Subject: Re: FP/295/17/DOC 31 Rife Way, Felpham

I am the case officer handling the above application to discharge conditions 3 and 4 of FP/21/17/PL.

11/21/17/PL

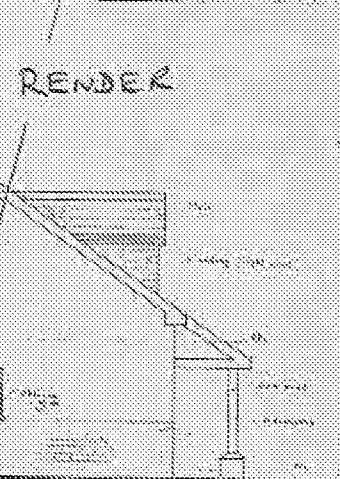
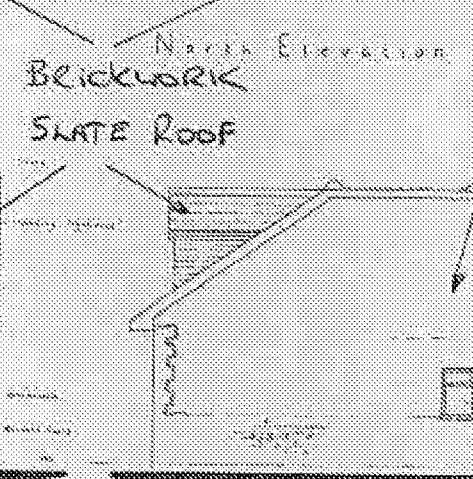
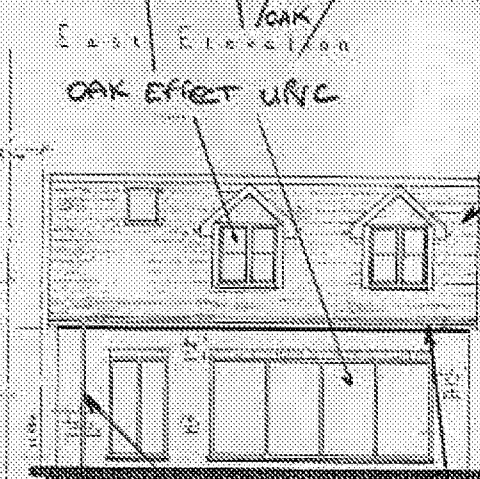
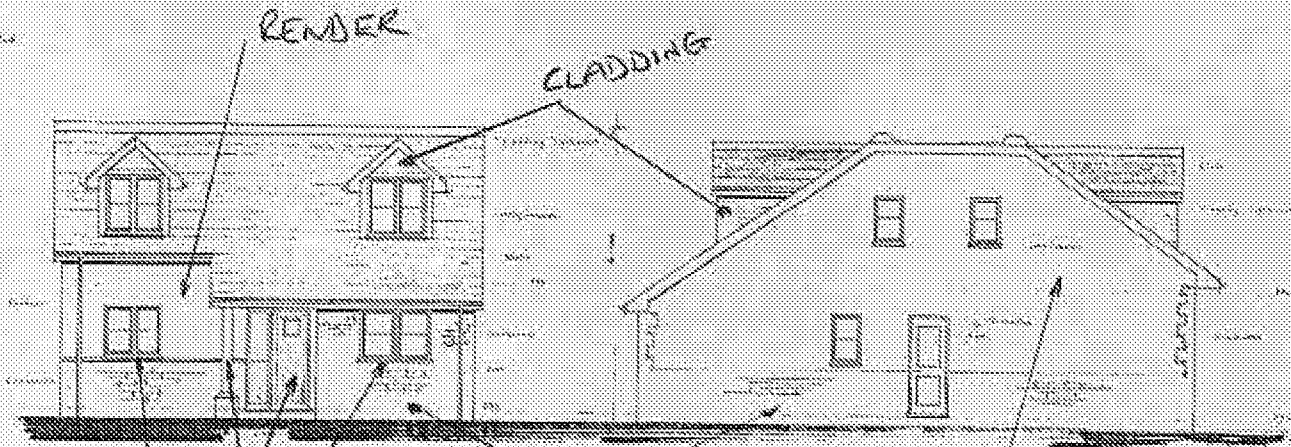
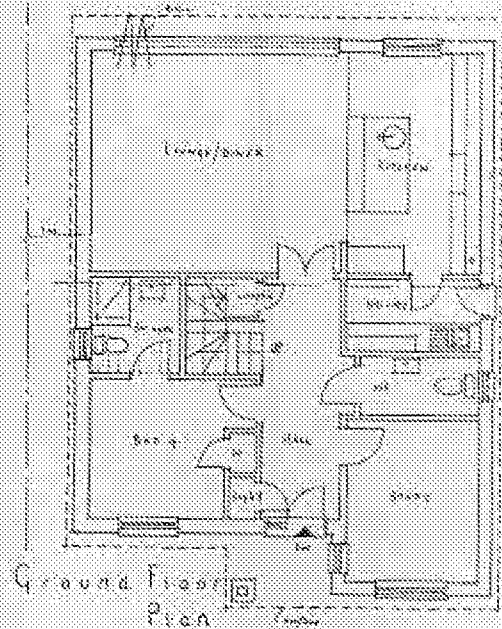
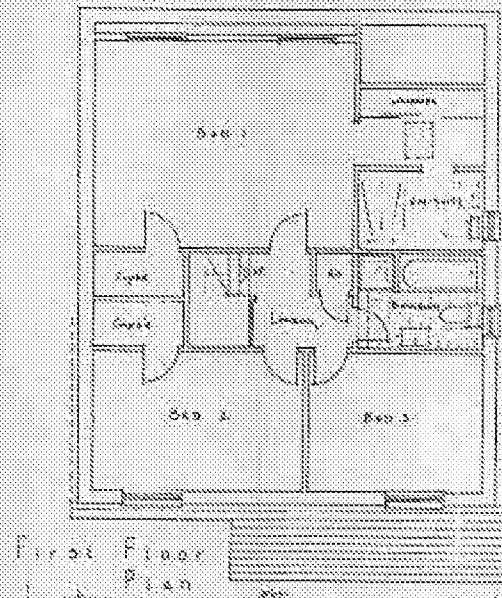
Sorry to chase but we'd like to get the decision on this out today. For materials we need to know the colour and type of brick proposed. We know the brick is to be red and the type pf slate, render and cladding proposed, but need to know the brick.

Do you have details of the extract external materials for the house to be used (as shown on drawing 01/16)? Colour of render, brick, slate tile etc? You may have submitted samples but I cannot locate these and we moved offices. I apologise if this was the case.

For the materials condition please confirm what colour the render will be.

The brick is weinerberger kassandra red brick, black Spanish slate, Marley eternate cream cladding with render to match.

previously owned land, as boundary was open (photo supplied) and continued in 4ft to the front of property. Flower beds to be planted with various perennial and annual flowers such as arum lily, penstemons, roses and geraniums. Sleeper wall erected 8m away from boundary with rife in an attempt to shroud garden from busy a259 which is on an embankment at the other side of the rife and is very imposing and noisy. Planting of trees would also help as a barrier, suggest willow to be in keeping with other gardens backing onto the rife. A rainwater harvesting system is to be installed and all non porous surfaces are to be channelled and piped to below ground tank. Patio material to be natural stone or slate. Concrete block pavior. Pea shingle drive (porous). Bins stored between two wooden gates in alleyway beside utility room. Render to be painted cream to match cladding (sample supplied).

FP/21/17/02 31 RICE WAY

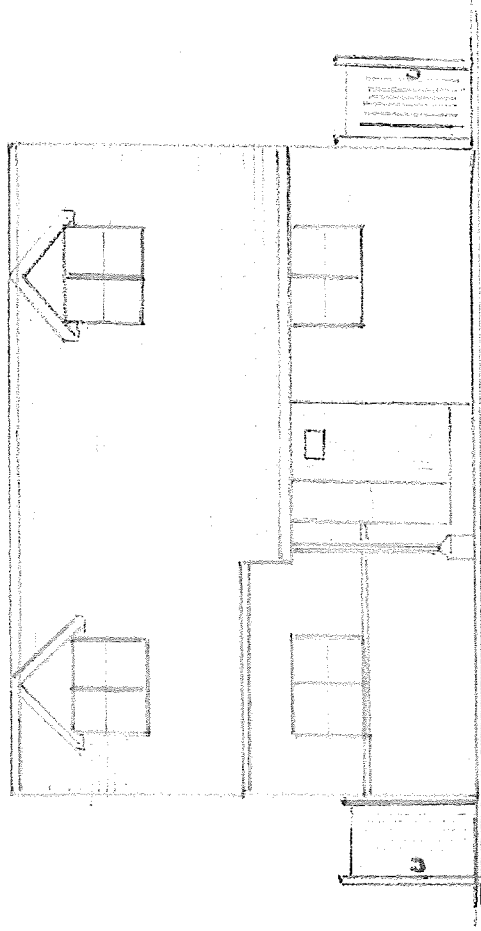
- A scaled drawing
- Elevations of the proposed fencing, gates, bin storage and sleeper wall etc
- Materials of fencing, hard and soft landscaping etc
- What material will be used for the shingle driveway, block pavers, patio? Will they be permeable for surface water?
- What species of plant/trees are being proposed?

NORTH ELEVATION OF FENCE TO NEIGHBOURS BOUNDARY

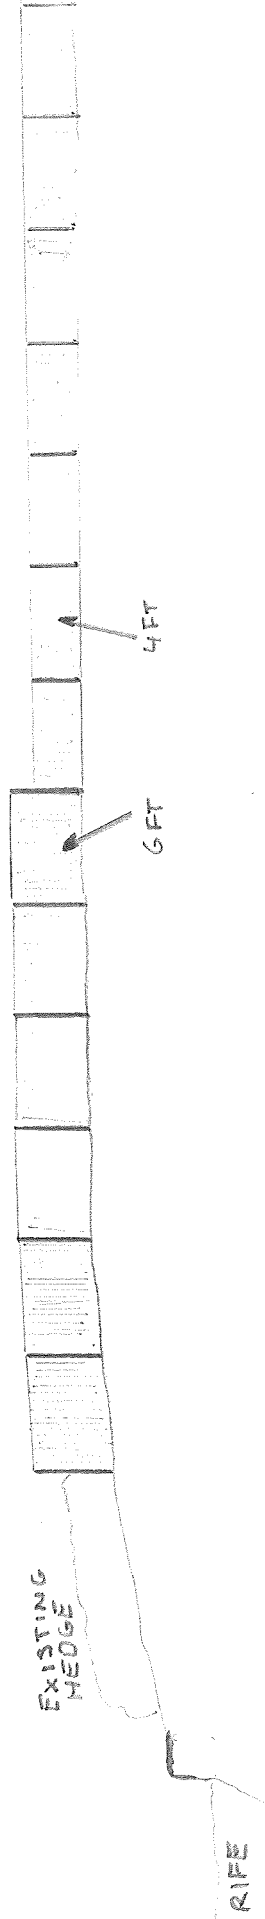
We need more detailed and a clearer scaled drawing for the landscaping condition. By this I mean (and this list is not exhaustive:-

In response to your email, the drawings already supplied are scale 1/200 rife to the east, road to the west (sorry forgot to write it on the drawings)

Wooden close boarded 6ft fence already erected on northern boundary at rear of property in agreement with neighbour who
